Application No: BE/101/21/HH
Site Address: 3 Homing Gardens Bersted PO22 9AJ
Description of works: Replace metal framed/wood panel workshop in rear with brick-built workshop
(This application may affect the character and appearance of the North Bersted Conservation Area)

Thank you for your internet representation made on 6th November 2021 which has been recorded as an objection with the comments as follows:

extending homes Tel:- 01243 555208 enquiries@extendinghomes.co.uk	
TITLE:- Outbuilding @ 3 Haring Gardens North Bersted West Sussex PO22 9AJ	
DATE:-	2nd September 2021
SCALE:-	Elevations Scale 1-100 on A2 Paper
DRAWN:-	P.Robinson
DWG. No. 2021078/PL/2

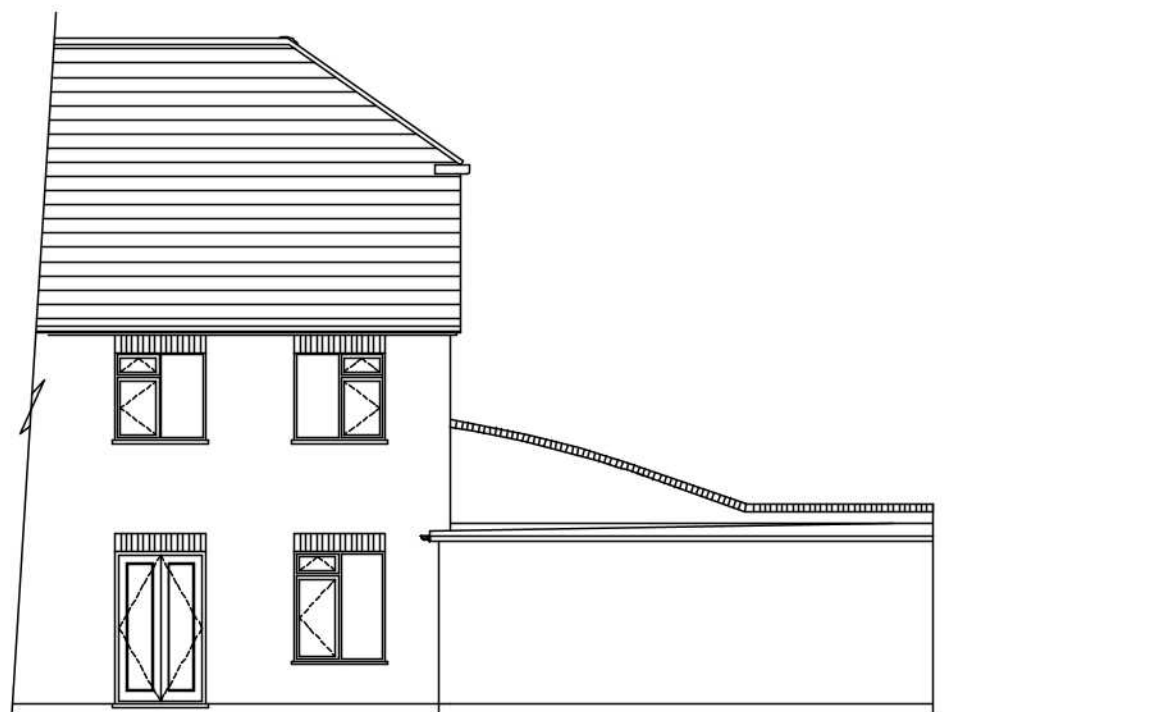
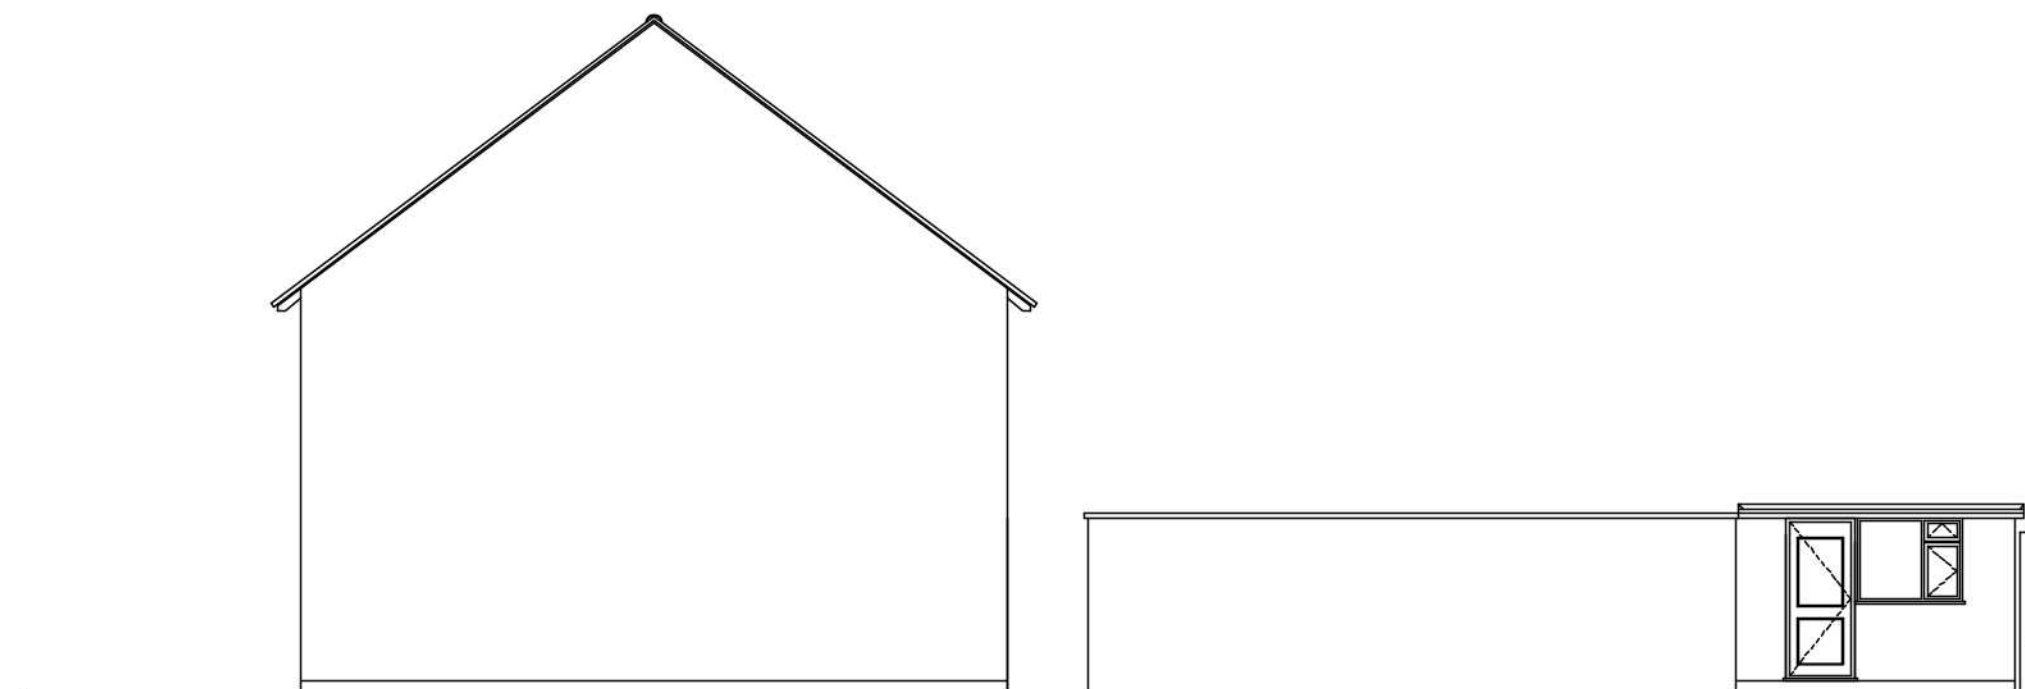
Objection to the development. its is In a conservation area.In the design and access statement. Mr Travers has not consulted with neighbours. Owner of No7 Garage objects to the development. The parking area in front of the development is jointly owned by the residents and is already in a poor condition already over crowded. Concern that the window in the development is the width of a garage door and would easily be changed. I understand that Mr Travers wants to repair cars. Concern that the area would become a mini car repair centre. The development would not be suitable to be tagged on to the single wall of garage No7 or the roof for that matter.
